Our Reference: SYD16/01626
Department Ref: SSD 8114

LINDFIELD LEARNING VILLAGE - 100 ETON ROAD, LINDFIELD

Roads and Maritime has reviewed the submitted application and does not support the development in its current form and provides the following comments for consideration:

Drawing Title  
 Turning Paths  
 14.5m buses

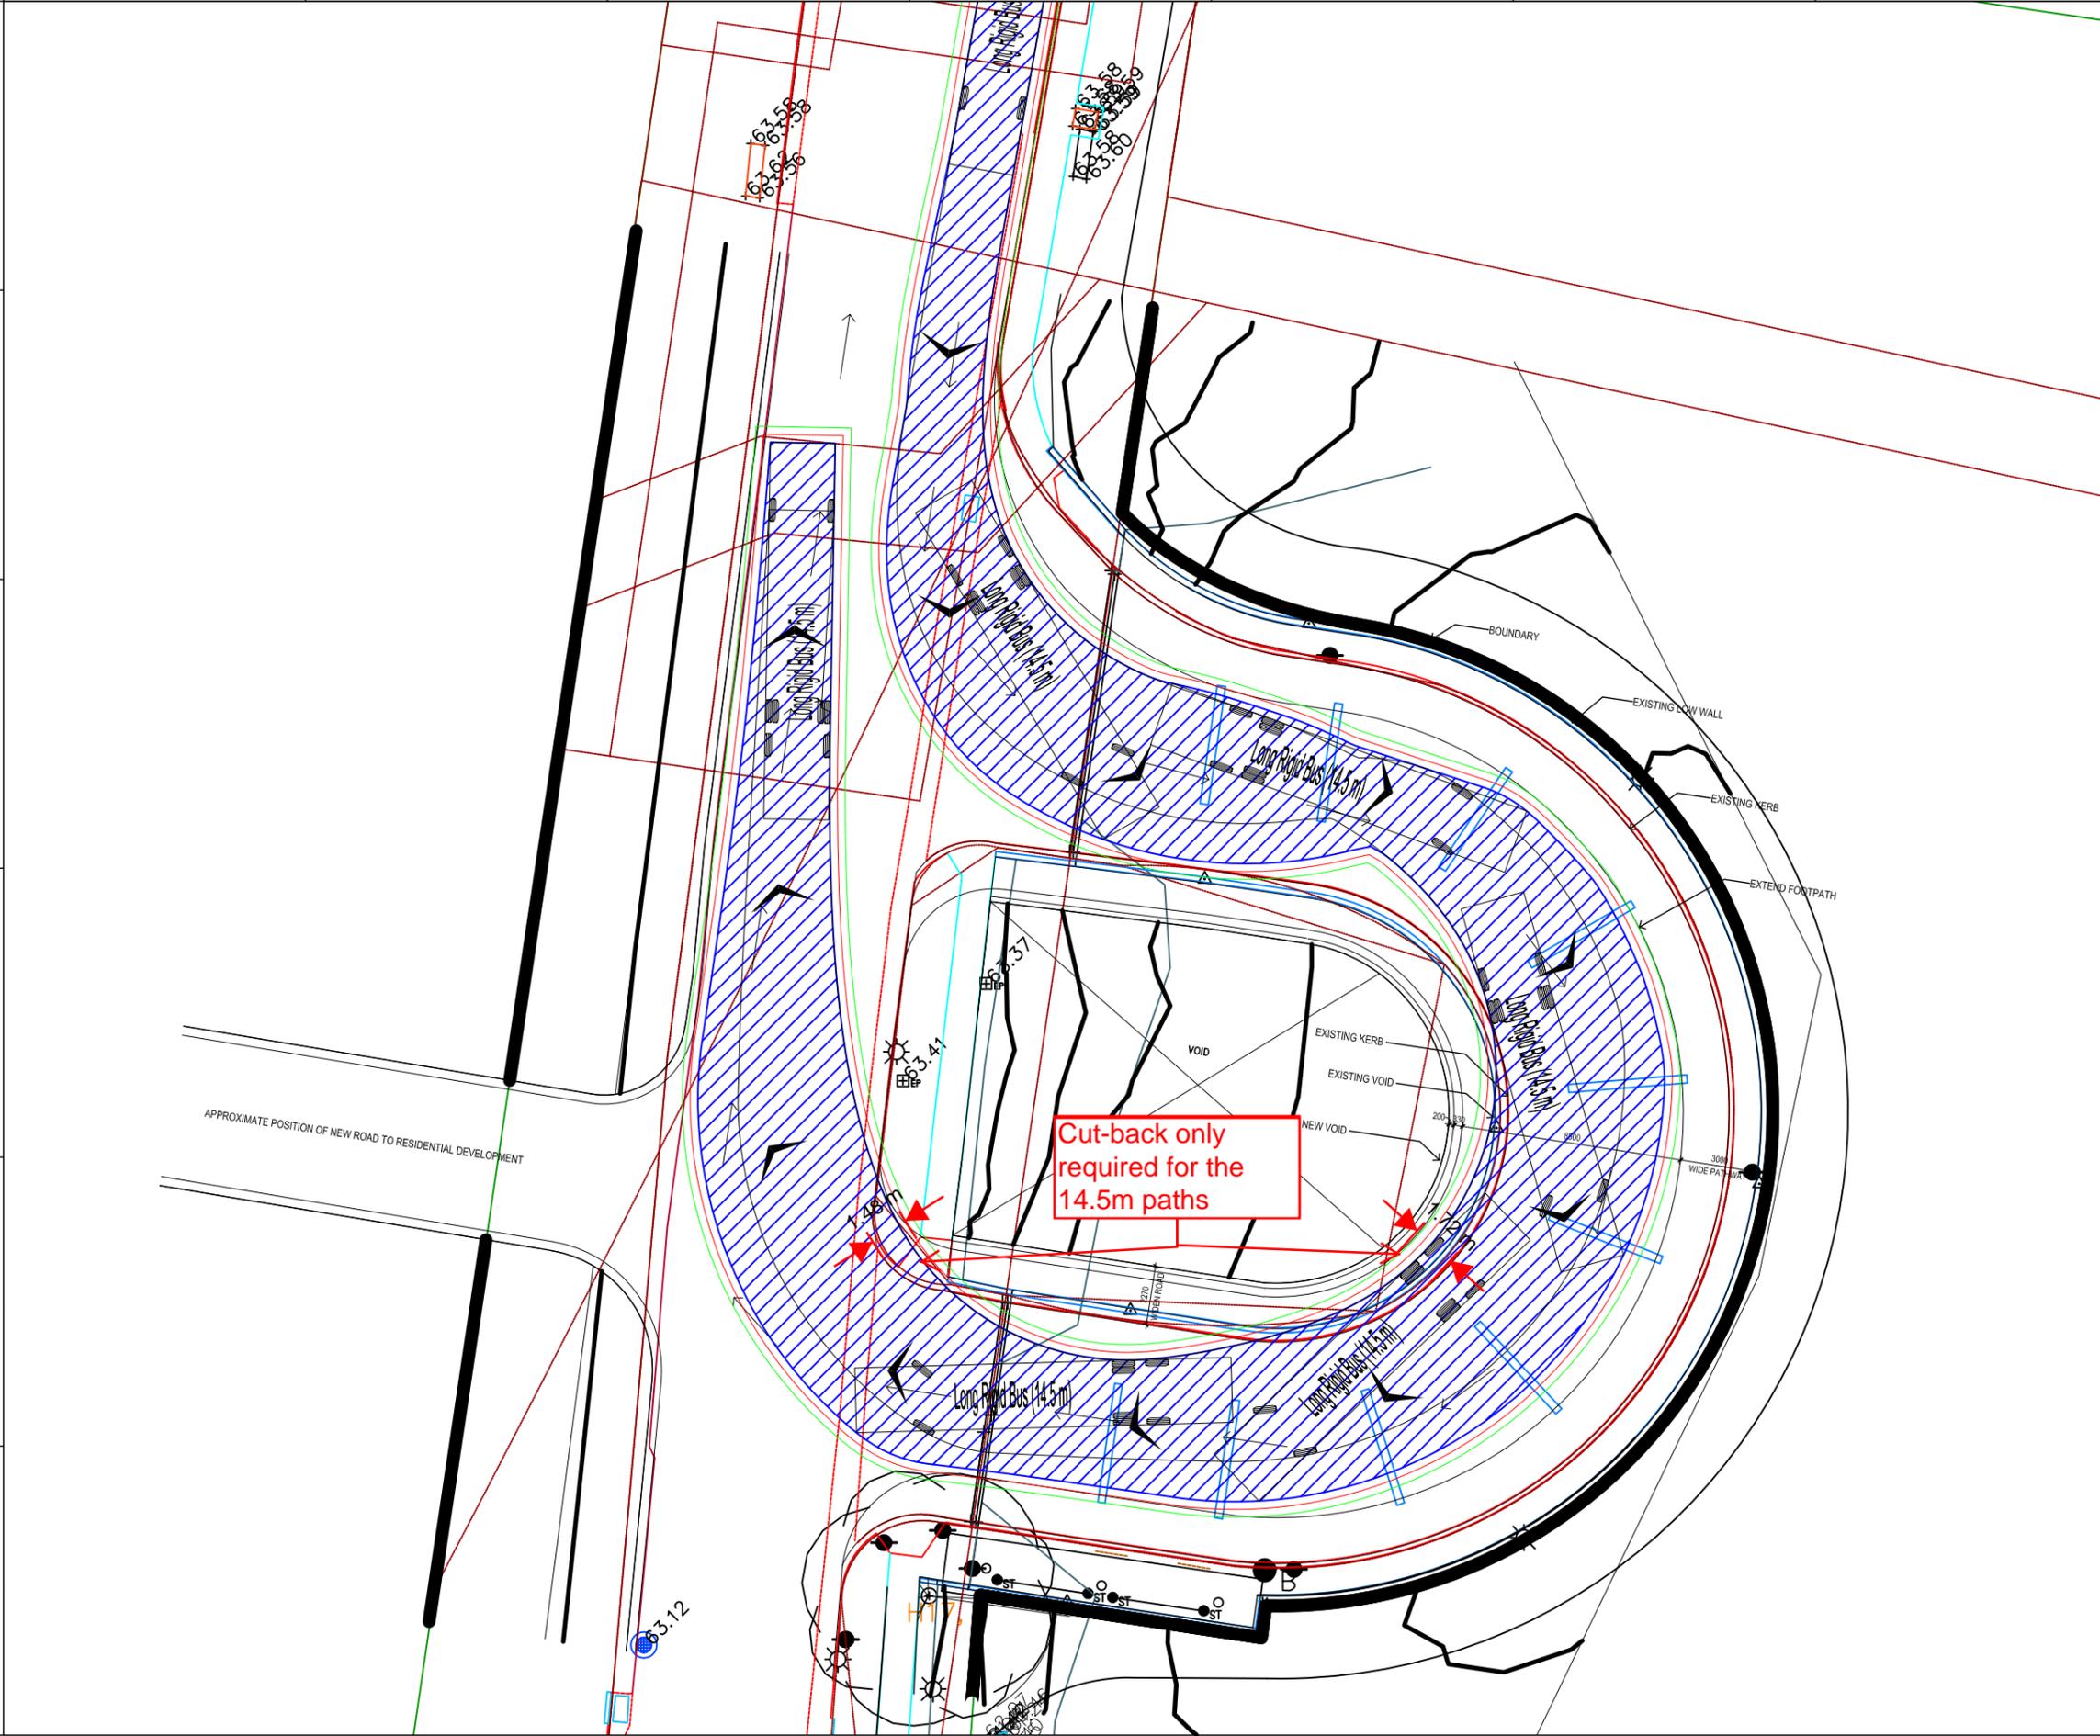
- Buses using the bus bay do not appear to have enough clearance to safely navigate the bus bay without rubbing up against concrete walls or pedestrian fences. The 600mm body clearance has not been achieved.
